MERITON TOWER

9 January 2012

**S.75W MODIFICATION TO MP10_0057 – RESPONSE TO ISSUES
132-138 KILLEATON ST, ST IVES**

BLOCK E ELEVATIONS

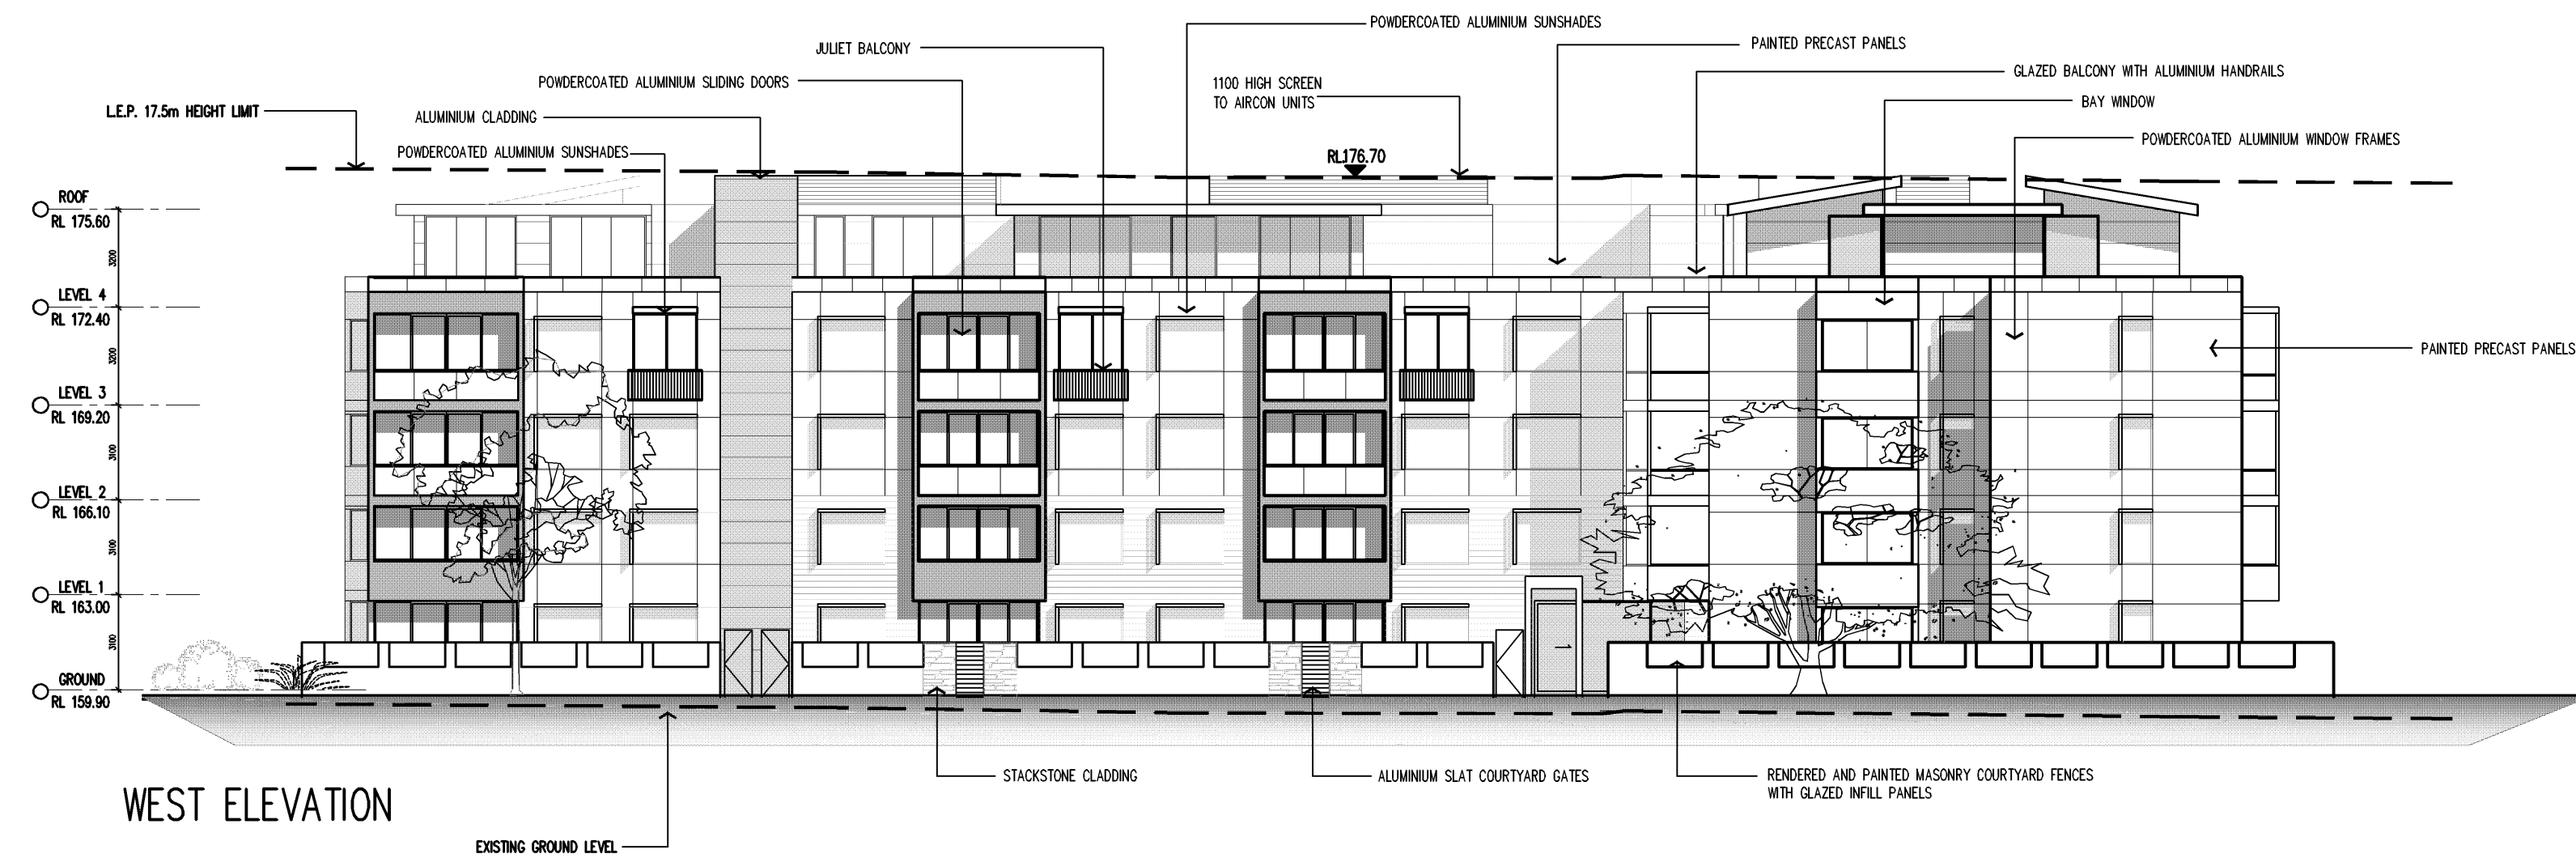
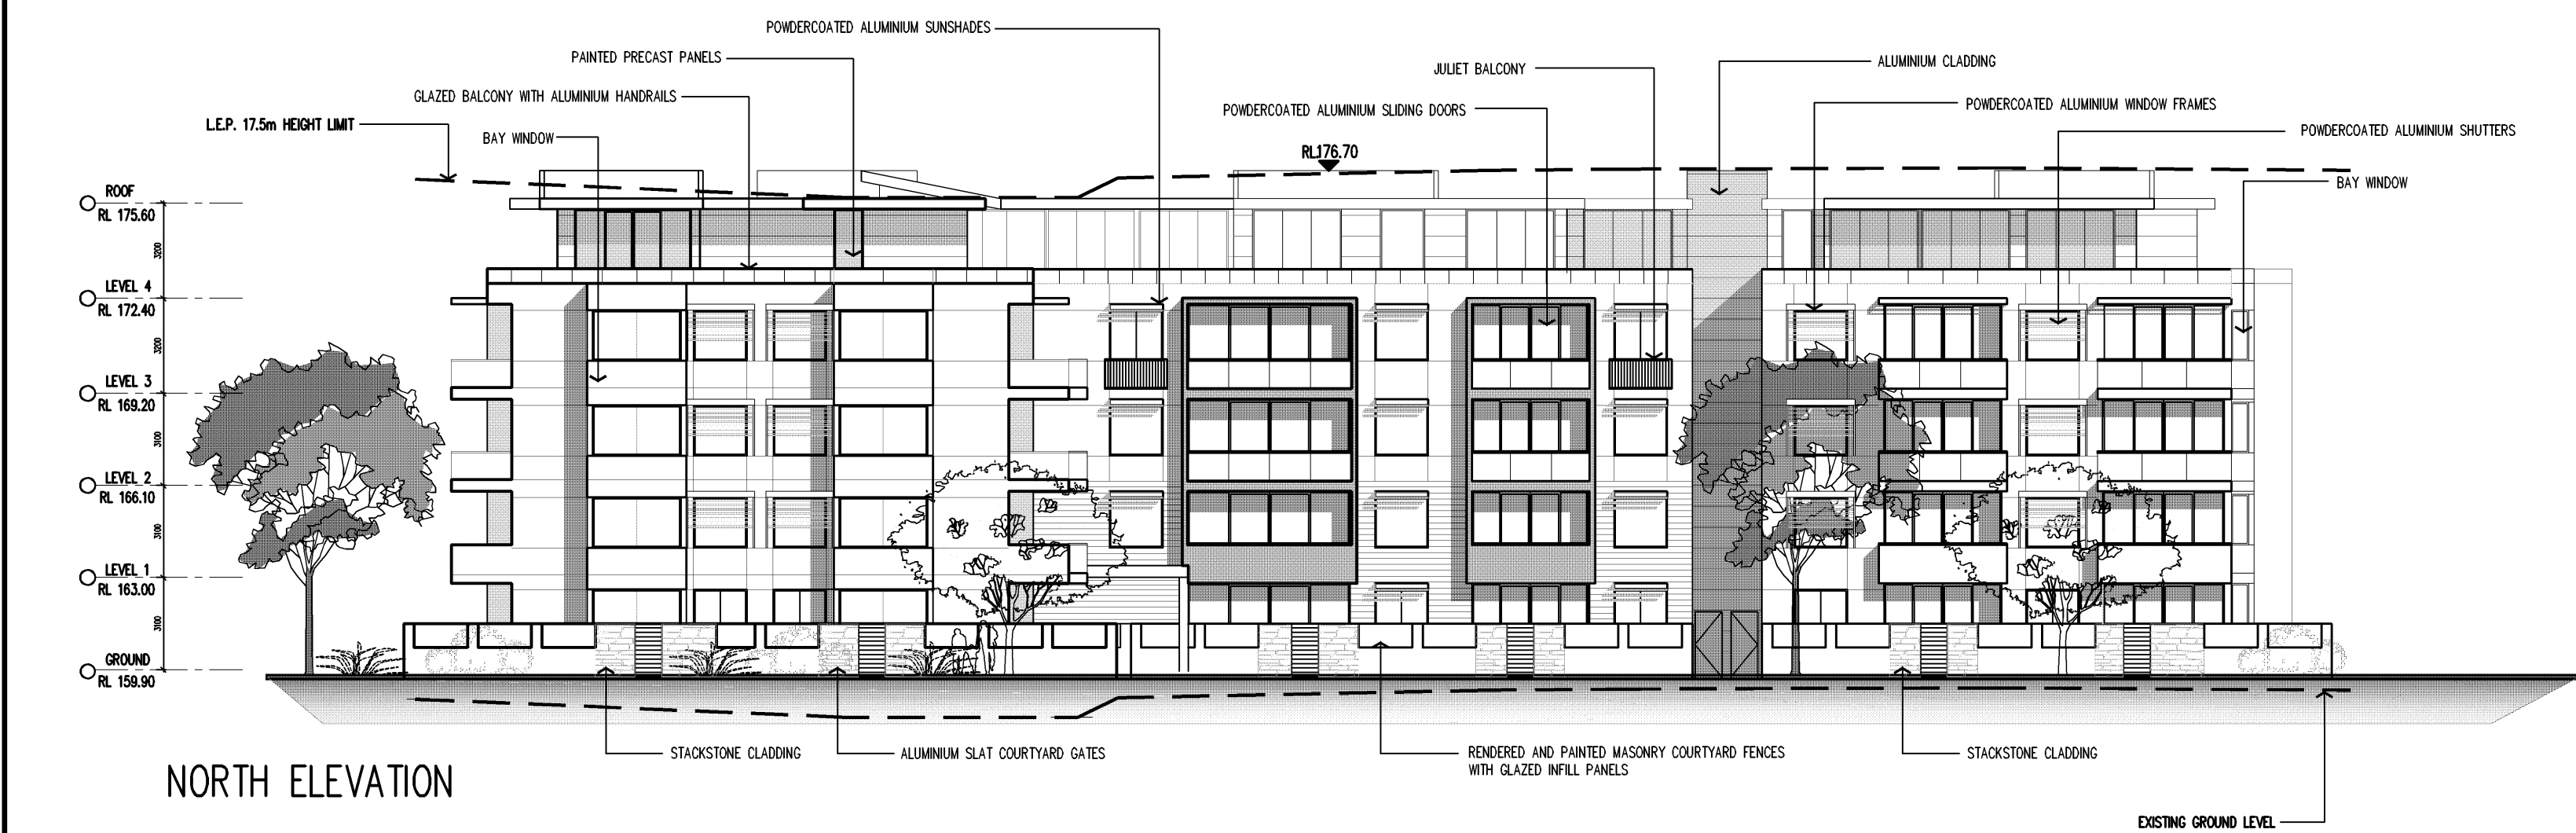
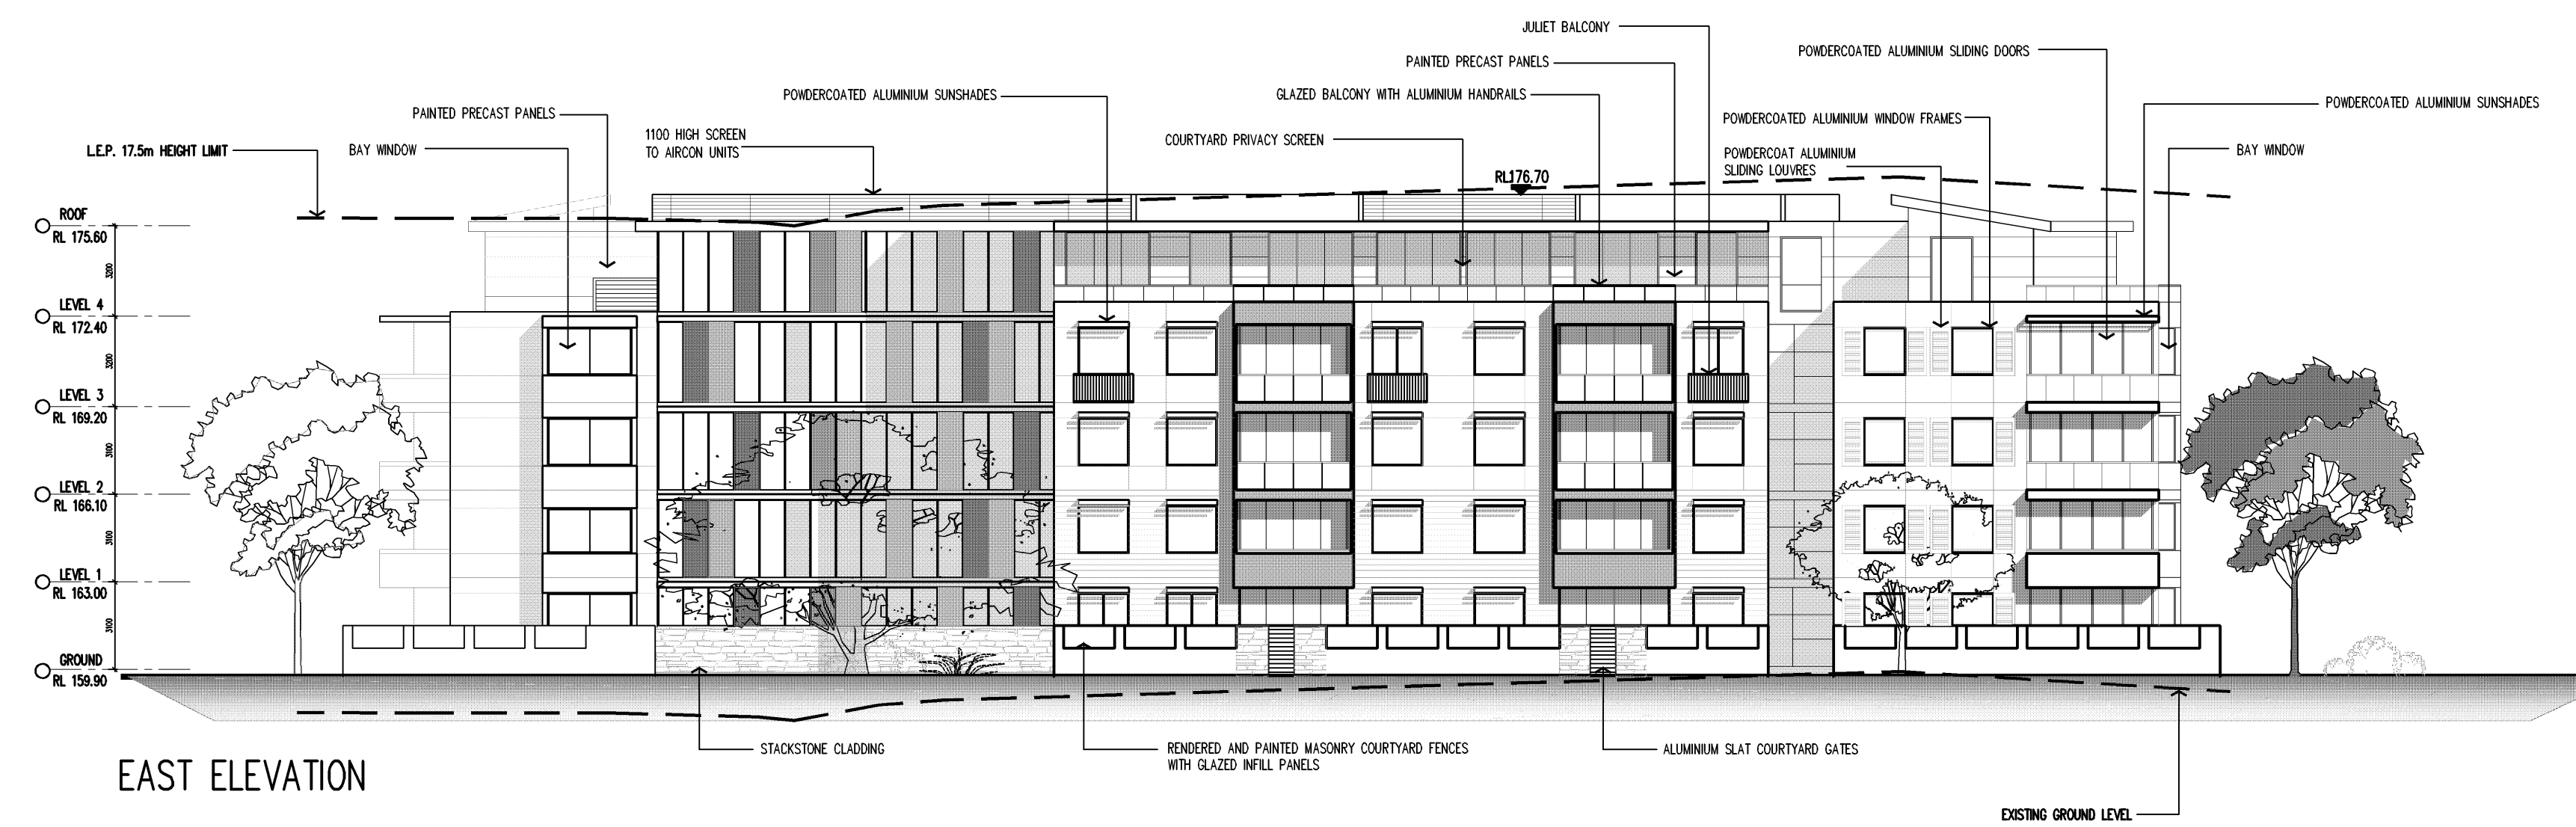
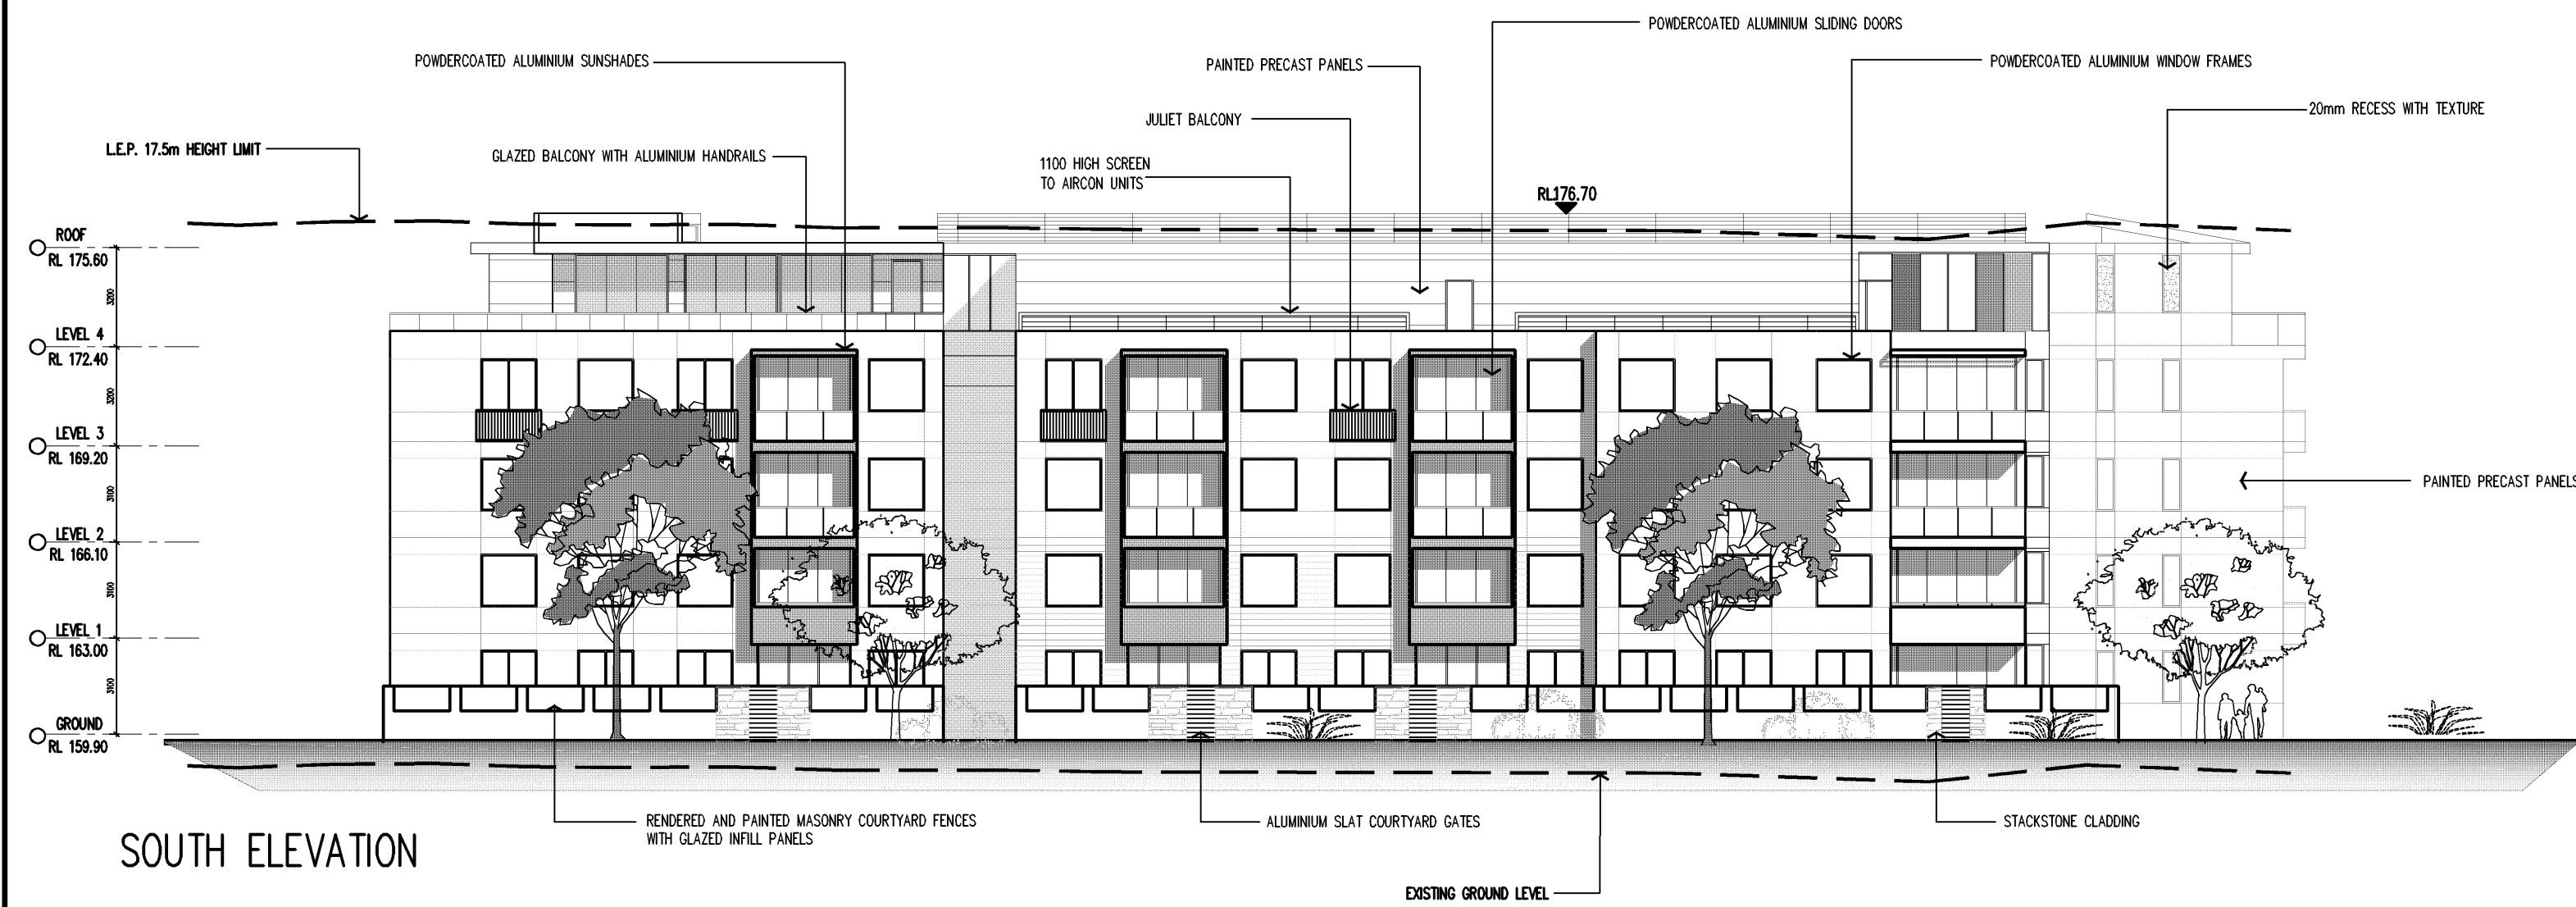
1. Skylights

2. Rooftop Water Heaters

Enclosed is a set of amended architectural plans that reinstate the skylights in the same locations as originally approved. The only difference between the proposed skylights and the ones that were originally approved is that we now propose to construct them with flat roofs.

It is necessary to construct the rooftop plantrooms at no less than 2.5 metres in height. Enclosed is a letter that has been prepared by our plumbing contractor, K-Mac Hydraulic Plumbing Services, which confirms that a 2.2 metre internal floor to ceiling height is required to install the proposed water tanks. The required 300 mm concrete slab roof to the plantrooms takes the total height requirement to 2.5 metres.
